From: Graham, Laura 
Sent: 19 June 2017 18:06
To: Michael Eastham
Cc: Claire Potts
Subject: FW: Fitzalan Link - LU.234.16.RES

Subject: RE: Fitzalan Link - LU.234.16.RES

In summary, there appear to be just three outstanding points now – the choice of road surface, the requirement for a new or supplementary Stage 1 Road Safety Audit and the design of the shared footpath-cycleway connection to Highdown Drive close to the new Toucan crossing now proposed. The other points can be tied-into the detailed S38/S278 submission.

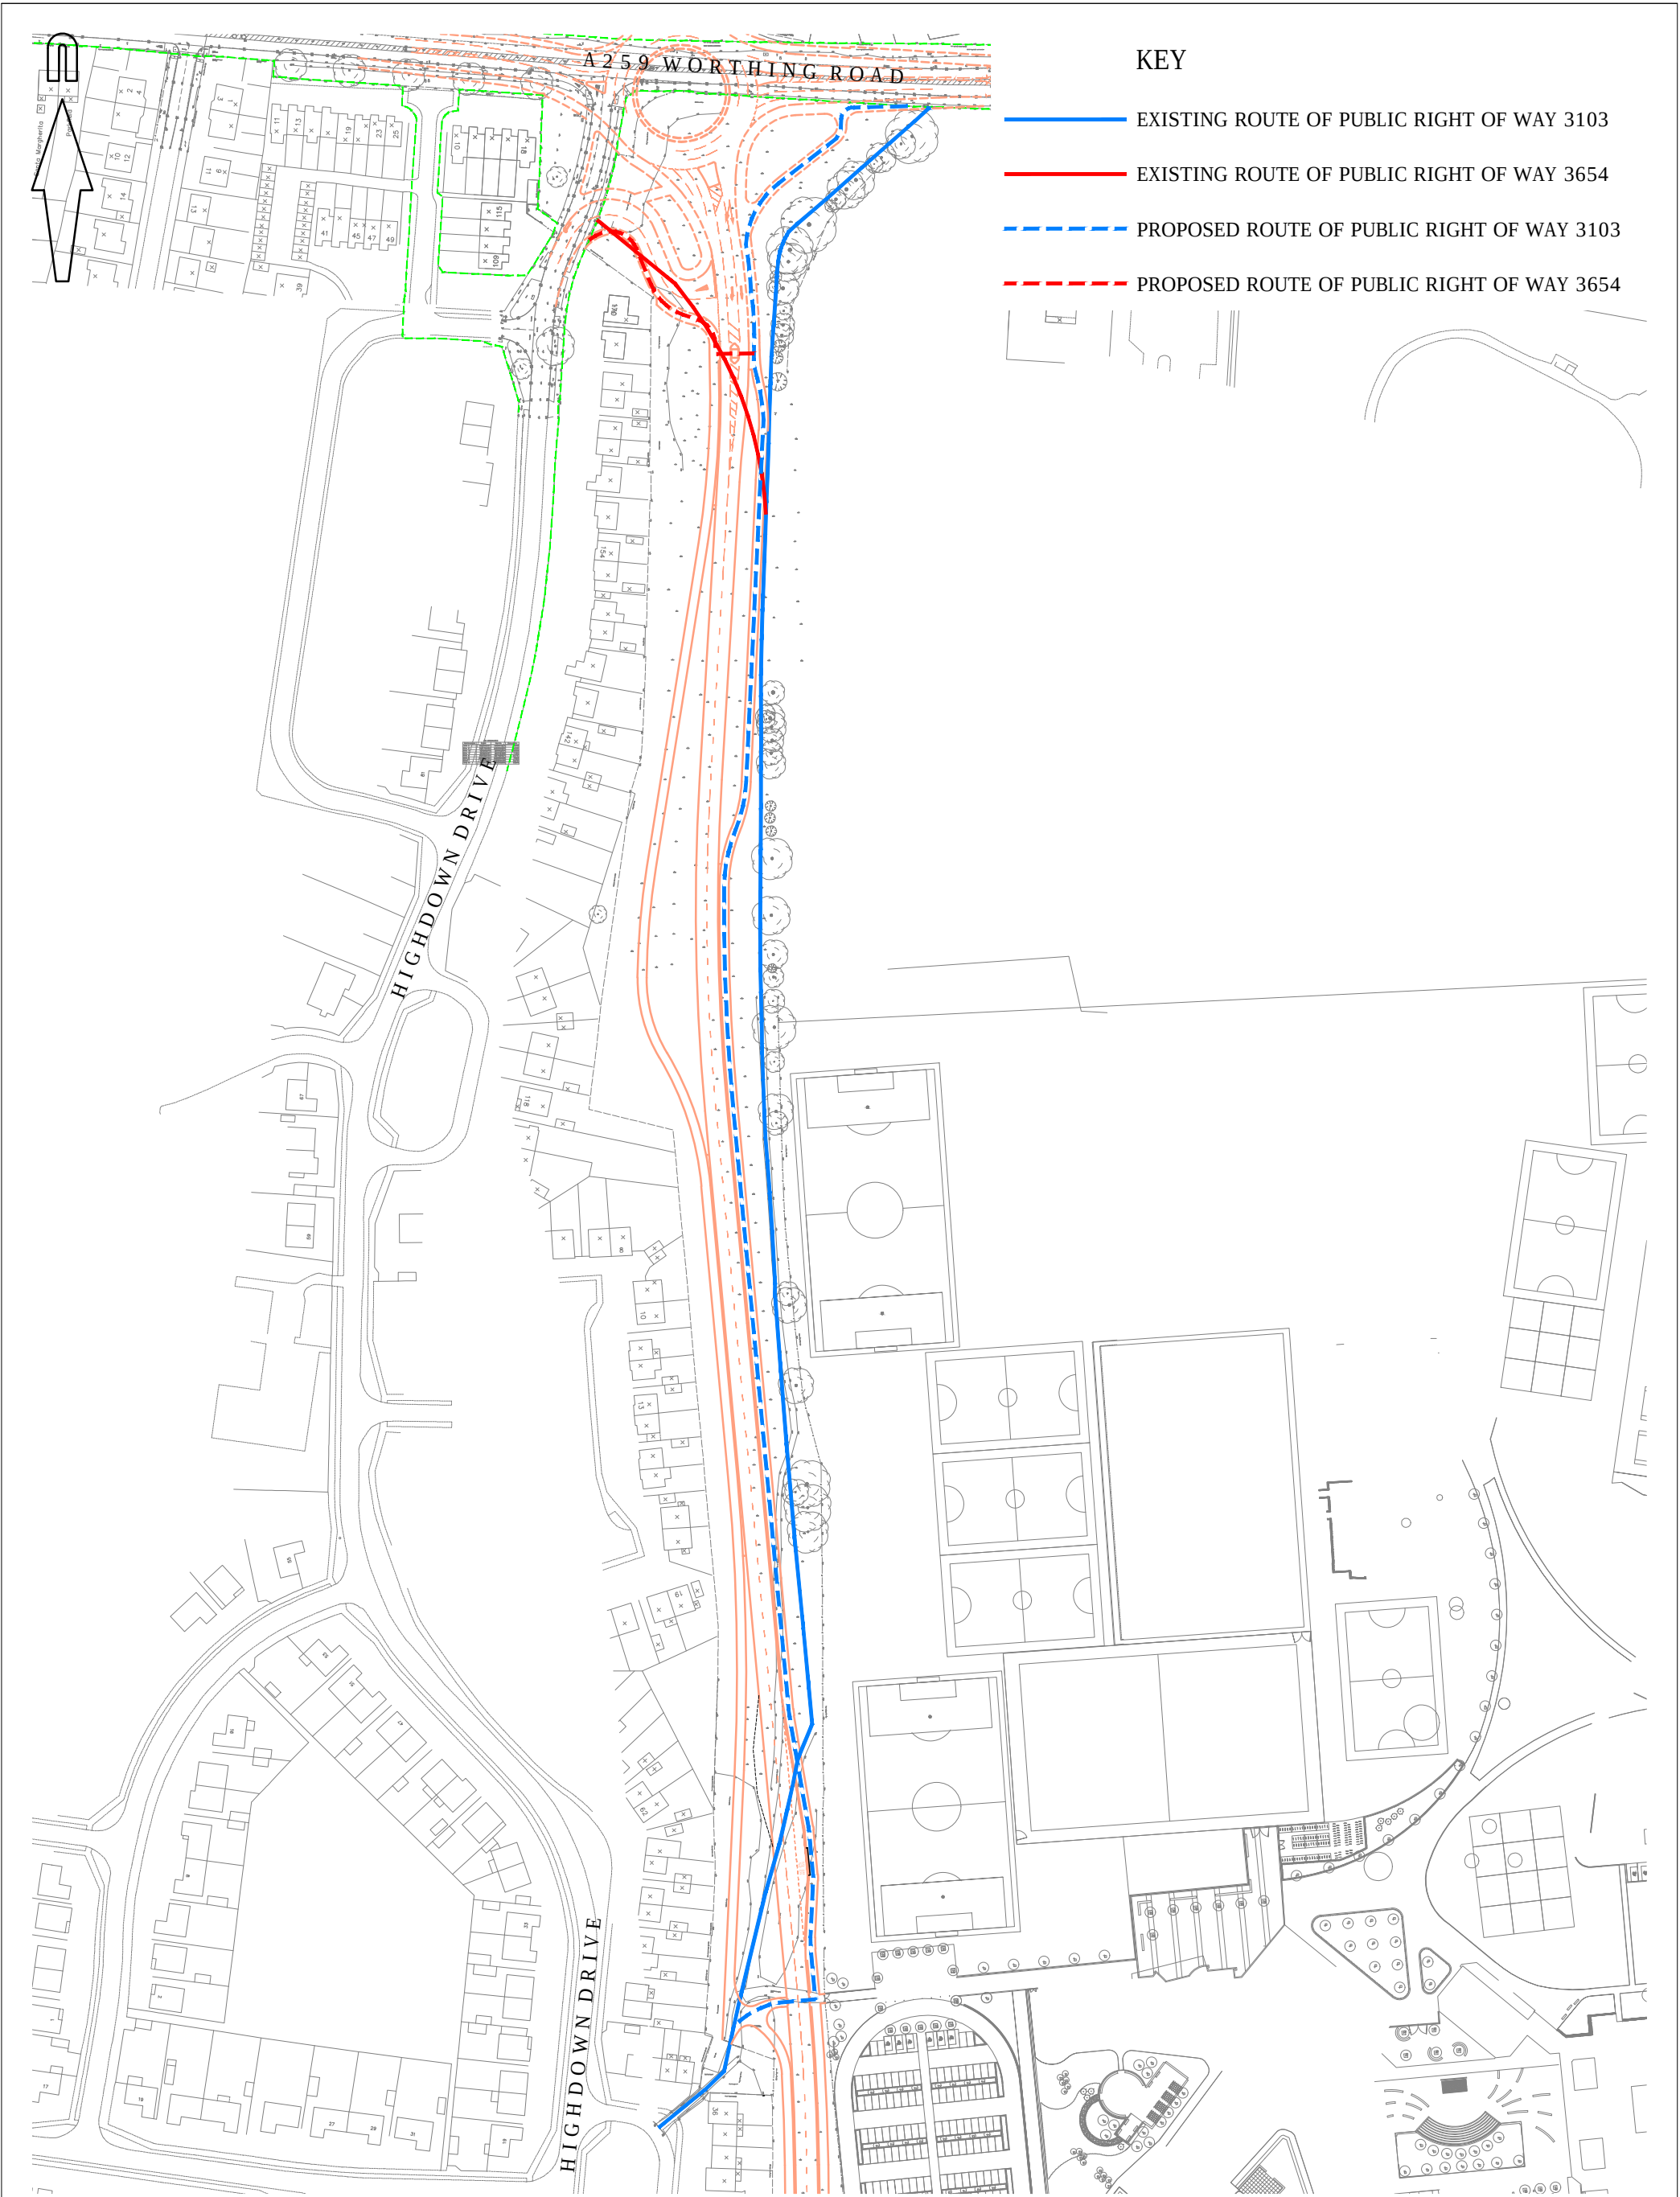
You have again offered an explanation for the path alignment in the vicinity of the Toucan crossing and balancing pond. The radii proposed are acceptable to us but the path must connect properly to the path leading to Highdown Drive which should be upgraded to a shared footway-cycleway. I have indicated below what this might look like. However, looking at this again shows the pink area to be public highway and on the line of part of Public Footpath 3103. Therefore, it is recommended (and indeed appears more straightforward) to retain this line otherwise it appears that any continuation of the route south of your scheme might cross land that might not be highway. Any path should be lit, edged, resurfaced, signed and tactile-paved appropriately although these final details can be shown at the S38/278 stage. Any upgrade from Public Footpath to shared footpath-cycleway must be undertaken in-accordance with WSCC PRow procedures.

Any changes to formal PRoW (temporary and/or permanent) must only be undertaken following appropriate WSCC processes and/or procedures and obtaining all necessary permissions – some of which are often separate from any planning application processes. Full details can be obtained directly from the PRoW team here at WSCC.

The highway boundary plan and alignment of the existing PROW is noted. However, this is not evident on the ground since the Academy has been constructed (see extract from Google Earth below). We can show the alignment requested, (based on the OS Highway Boundary plans provided) but we would only have the power to construct the pathway up to our limit of ownership (the red line). WSCC has less than Freehold rights beyond the red dashed line and as such we don't believe we would have any power to undertake works on this area of land (see attached) to effect the PROW route beyond the red line, hence the reason for showing the tie-in (at the limit of ownership) to the existing physical route present on the ground. Therefore, we believe that what we have shown on the submitted drawings is the best solution, unless WSCC can confirm that we could legally obtain power to undertake works on land that they don't have complete freehold rights over.

I have already sent a note on this. We will be submitting the diversion request under the TCPA to ADC. Once plans for the Fitzalan Link have been confirmed / approved I will start this process with relevant personnel at ADC. It is not a matter for WSCC.
